Pre-application planning advice

Application ref: DC/23/4214/PREAPP

Homeleigh
The Common
Southwold
Suffolk
IP18 6HR

Pre-application advice is sought for the revised design of a first floor canopy over roof terrace. The applicant has been advised that works carried out to date are not appropriate within the Conservation Area.

ELEVATIONS AS PROPOSED

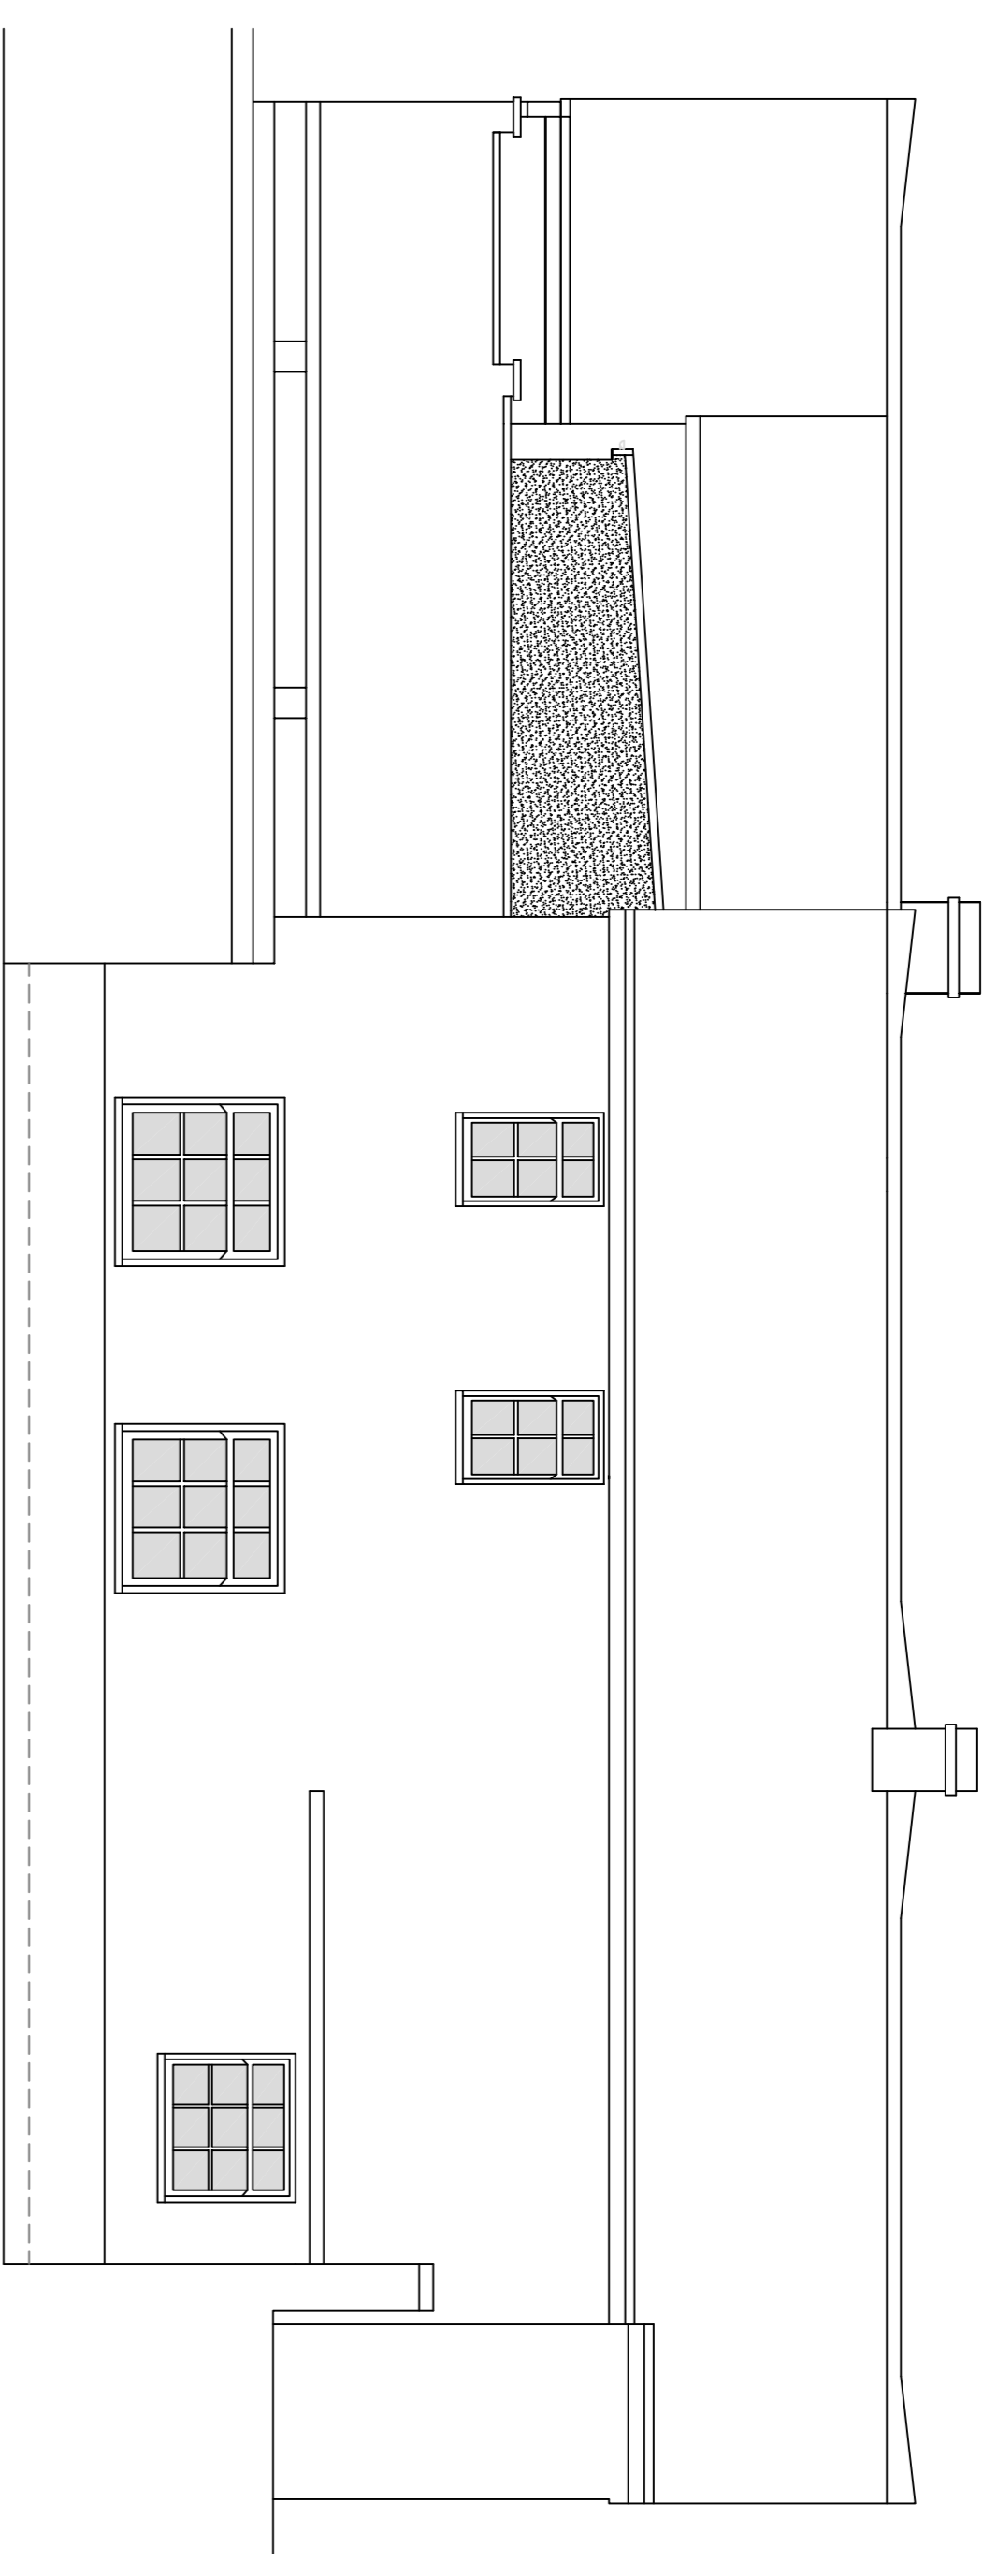
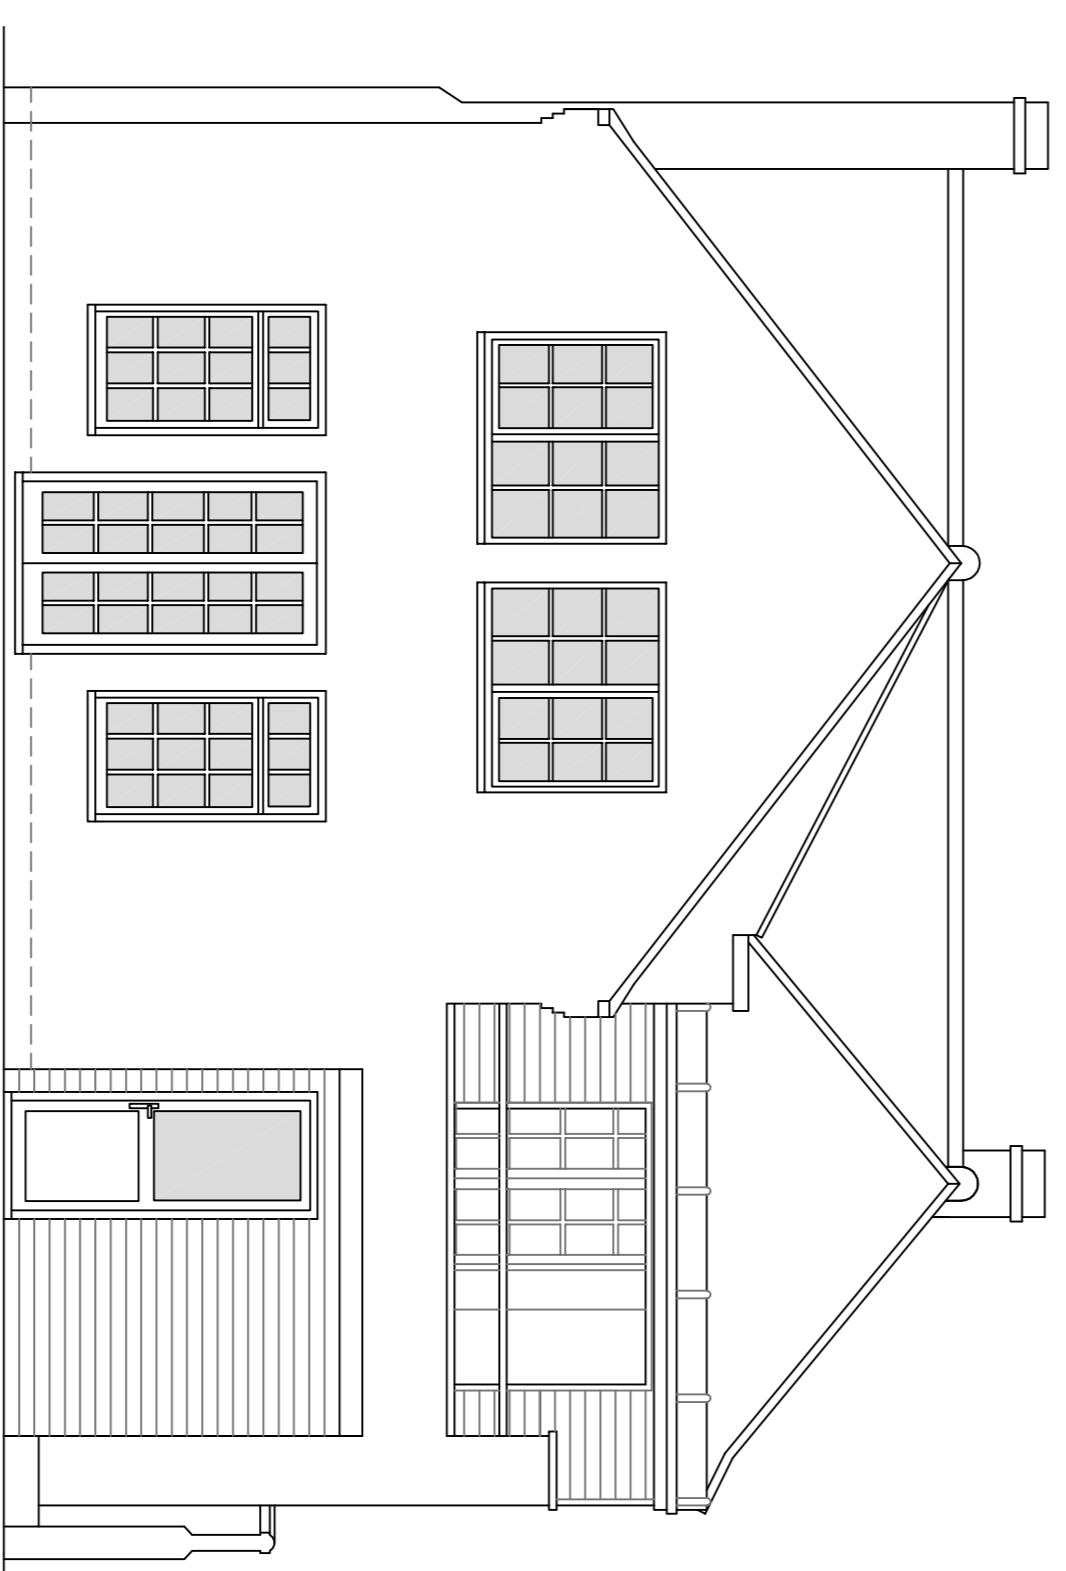
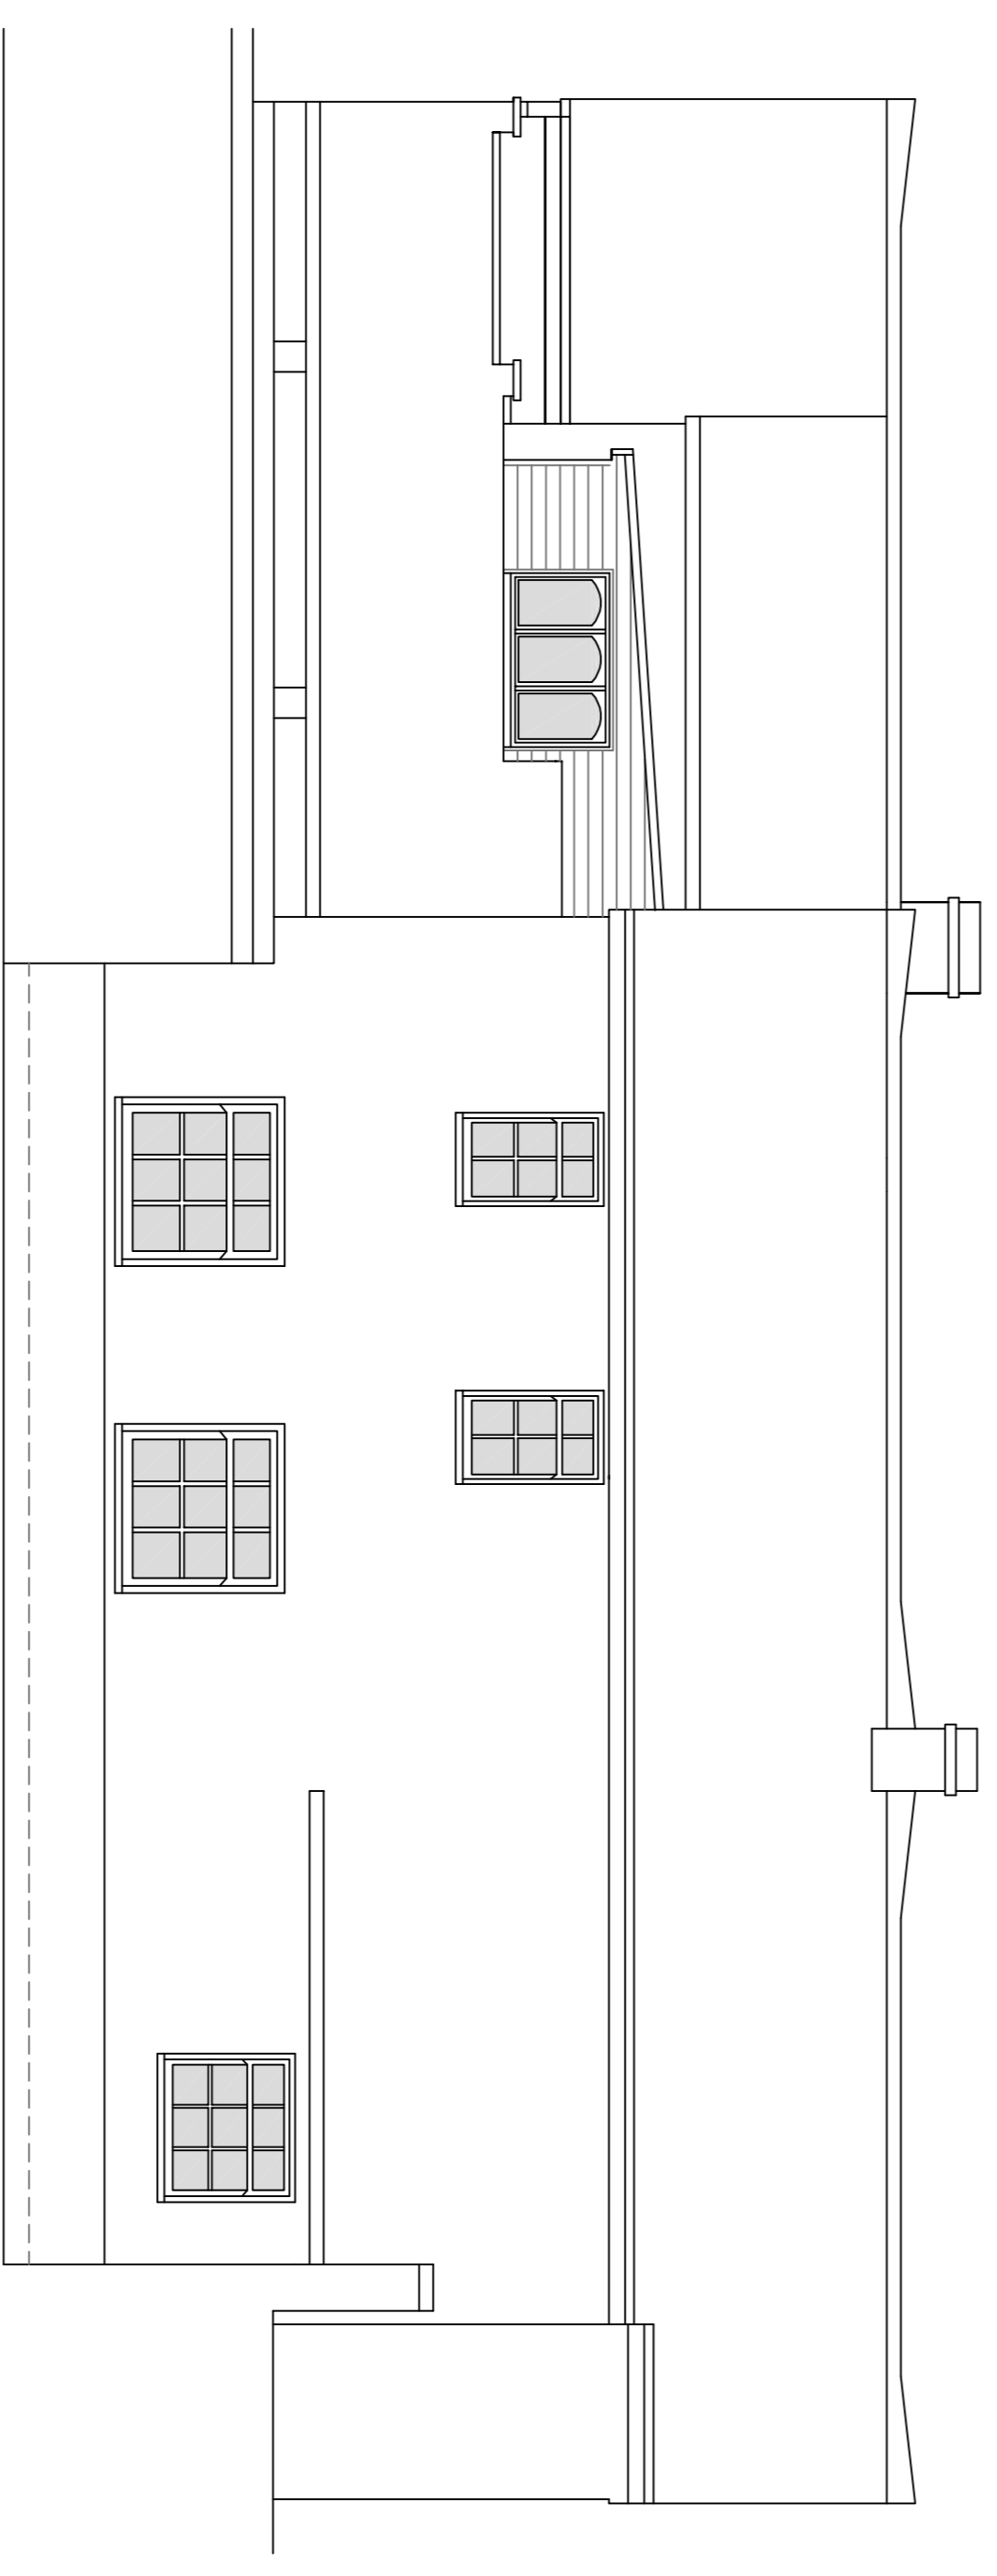
The proposed design would replace the upvc cladding with red brick to match the side wall of the property. This choice of material would be much more acceptable in the Conservation Area. It is not clear exactly what form and appearance the original terrace area had - it would be useful to have an idea of this if a formal application is made as we would assess the proposal against the lawful size/design/appearance of the property, not compared to any unauthorised works as existing.

The proposed drawings also refer to the use of k-rend however it is unclear exactly where this would be - presumably the front elevation. This would likely be acceptable as set behind the existing front wall of the terrace and therefore screened from public views. It is not clear what the original or proposed roof material would be. Assuming the previous structure was light-weight and the proposal is for similar, this is likely to be unobjectionable.

The works as carried out are unlikely to be acceptable if an application were made for their retention; however the proposed drawings showing a similar sized structure of a similar form using red brick to match the existing side wall, and assuming a similar front elevation to that previously on the property, the revised scheme is likely to be supported by officers. It will, however, be important to undertake a site visit to fully consider the potential impacts as part of any formal application. If a formal application is made, we will need details of the original structure that was there, not just of the existing in its unauthorised form.

ELEVATIONS AS EXISTING

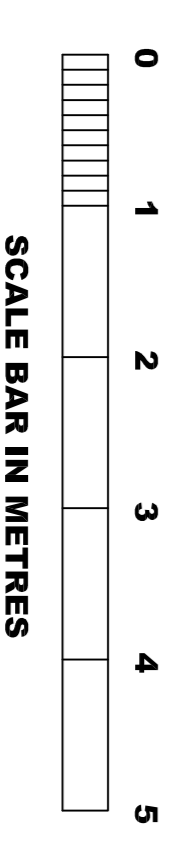
For the development to be considered acceptable, the design must accord to the requirements of the above policies. The use of upvc cladding within the Conservation Area in the form as existing is not appropriate and an application for its retention is unlikely to be supported.

It also appears that the garage door below this area has been bricked up with a pedestrian door installed. It is not clear exactly when these works took place or exactly what works have been carried out. It is advised to include details of this in any future application for clarity.
